ENG-SF18025-R2-Plat_Redlines.pdf Markup Summary

ENG-SF18025-R2-FDR_Redlines.pdf Markup Summary

ENG-SF18025-R2-CDs_Redlines.pdf Markup Summary

SHEET: CH1

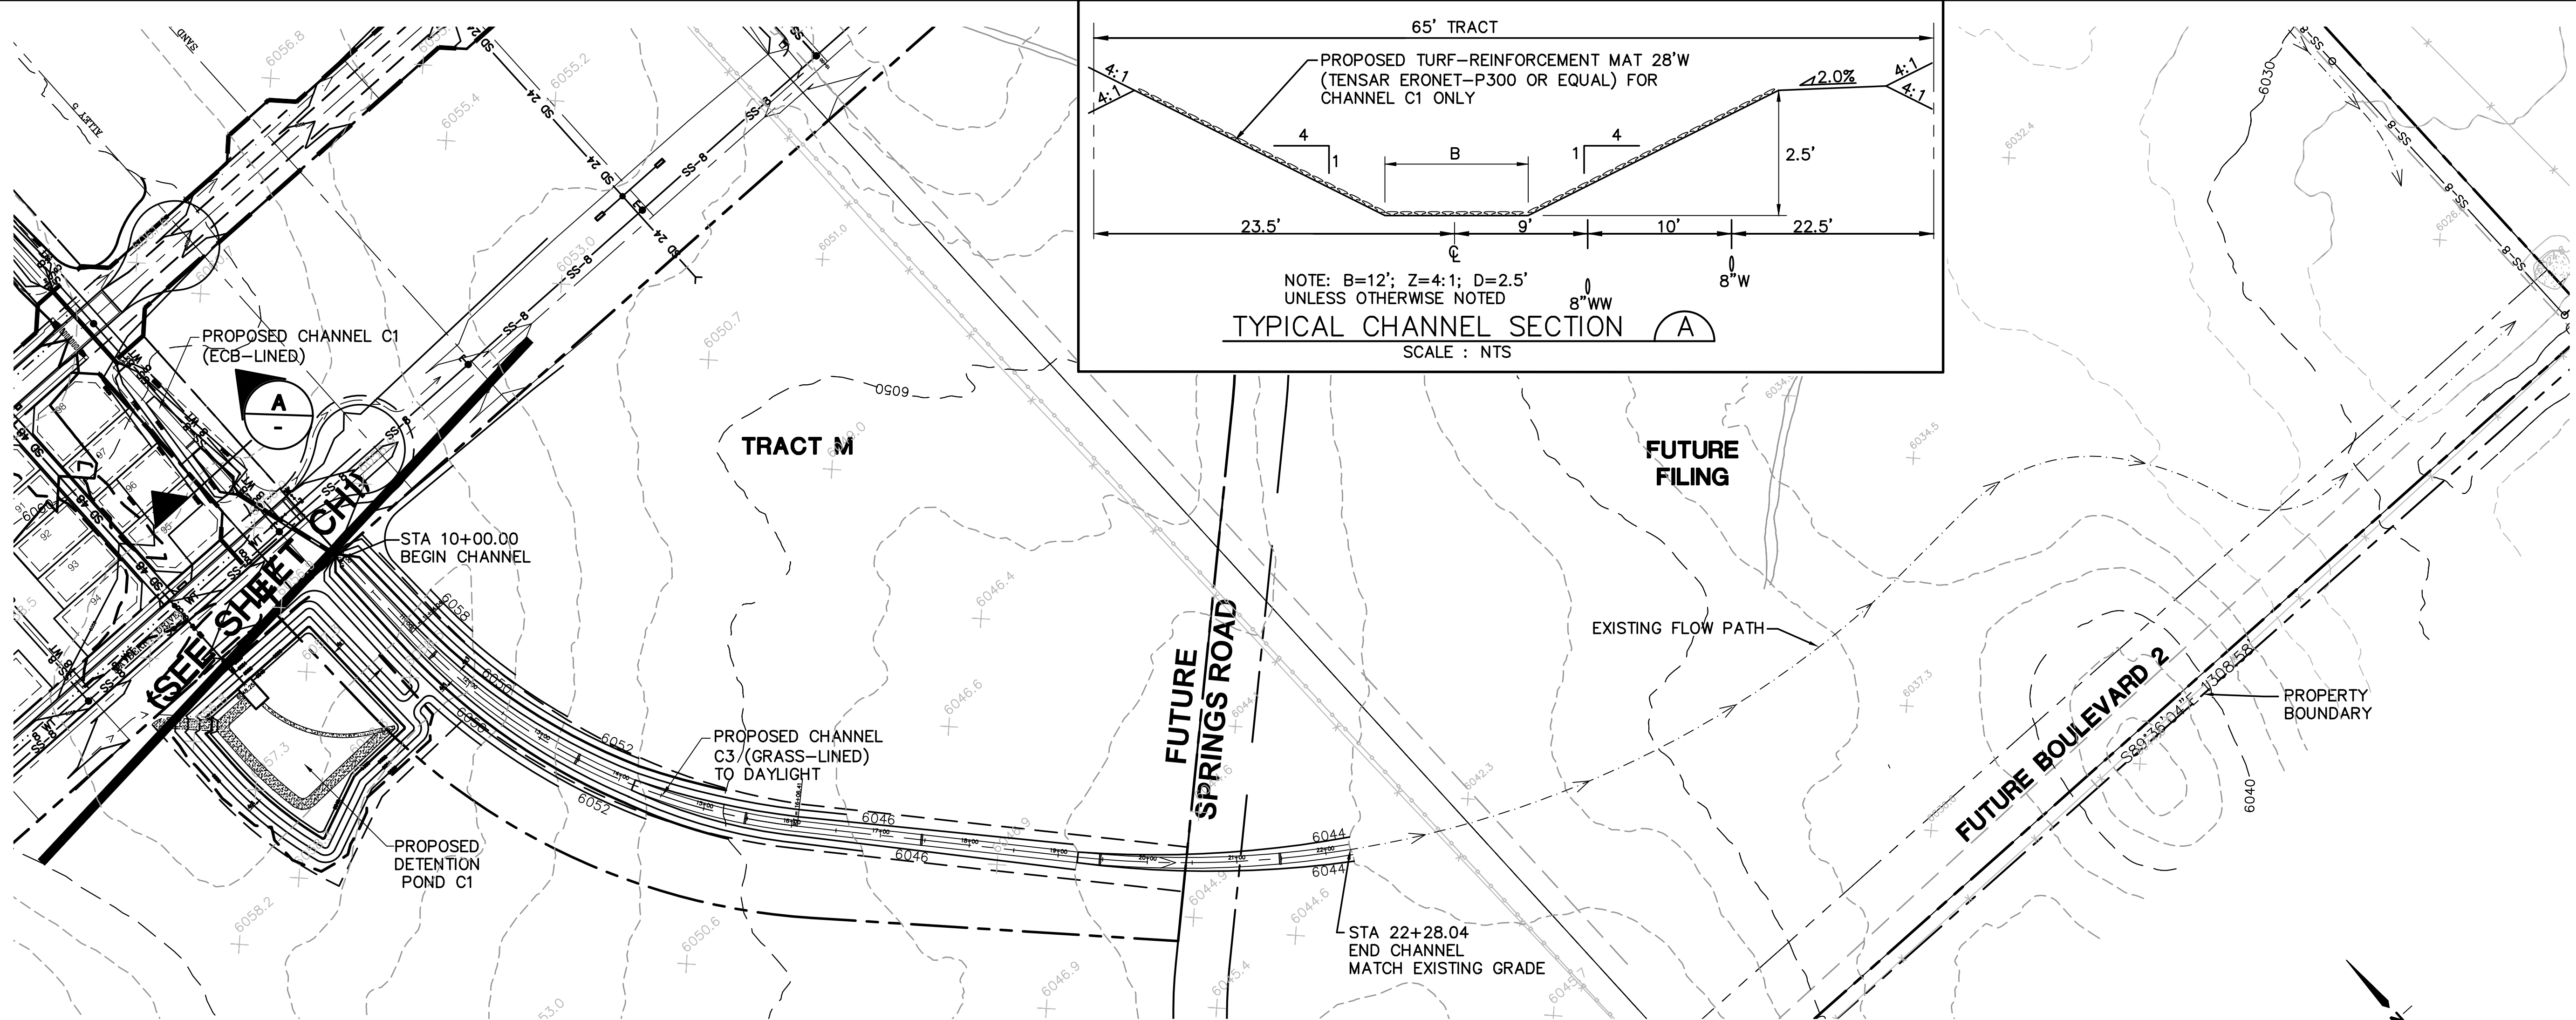
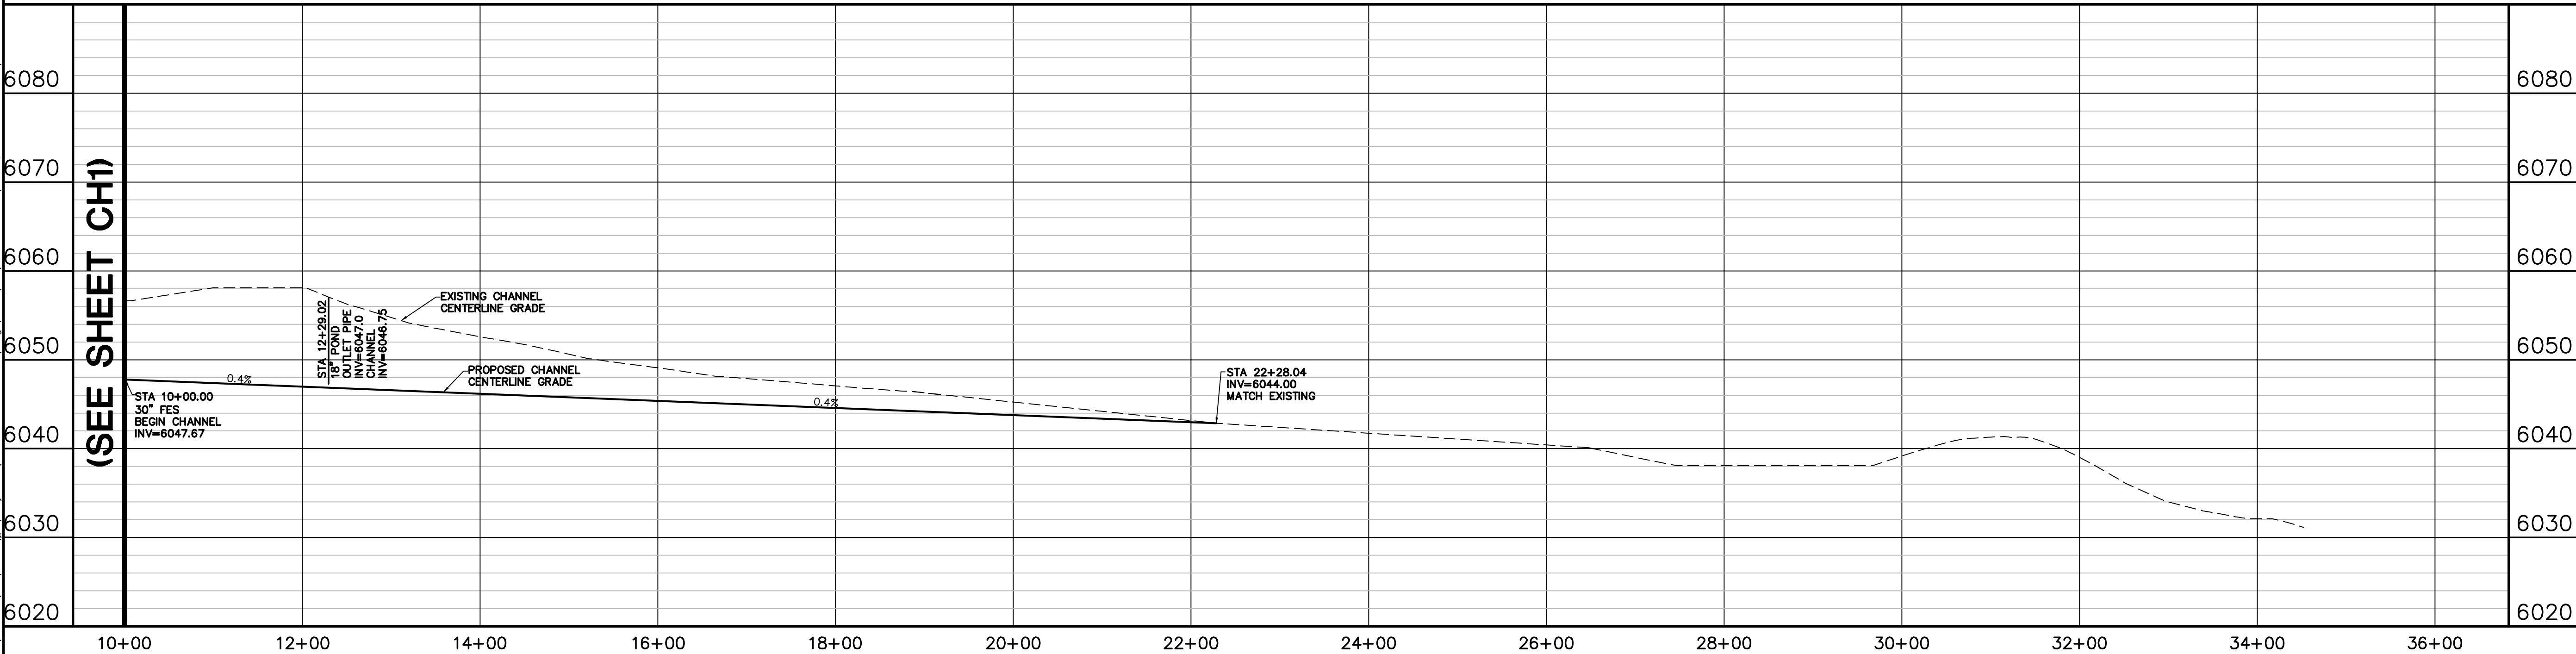
show tie-in

How does ditch flow get into road/inlets?
